# City of Albuquerque

March 2, 1987

RE: REVISED DRAINAGE PLAN FOR AZUELA'S WOODS  
(J-14/D67) RECEIVED FEBRUARY 25, 1987

DRAINAGE & GRADING PLAN

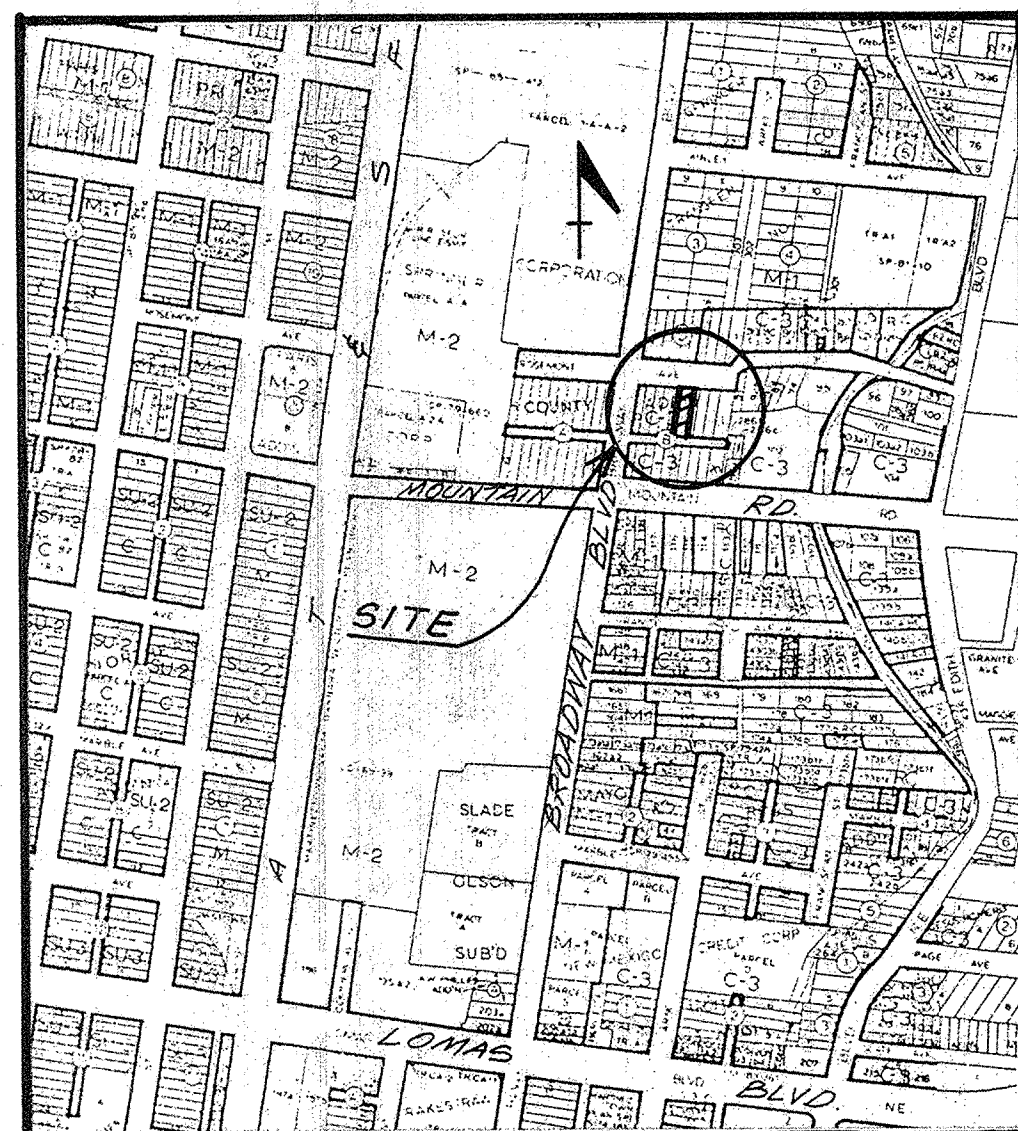
1. In order to allow that no approved alley grades or improvements to the alley be waived, we will need a more permanent blockade on the south property line other than just a fence (garden wall or curb would be appropriate).
2. We will also need assurance that by the proposed building blocking off-site flows from Lot S, no sediment will be routed towards and into Rosemont Avenue.
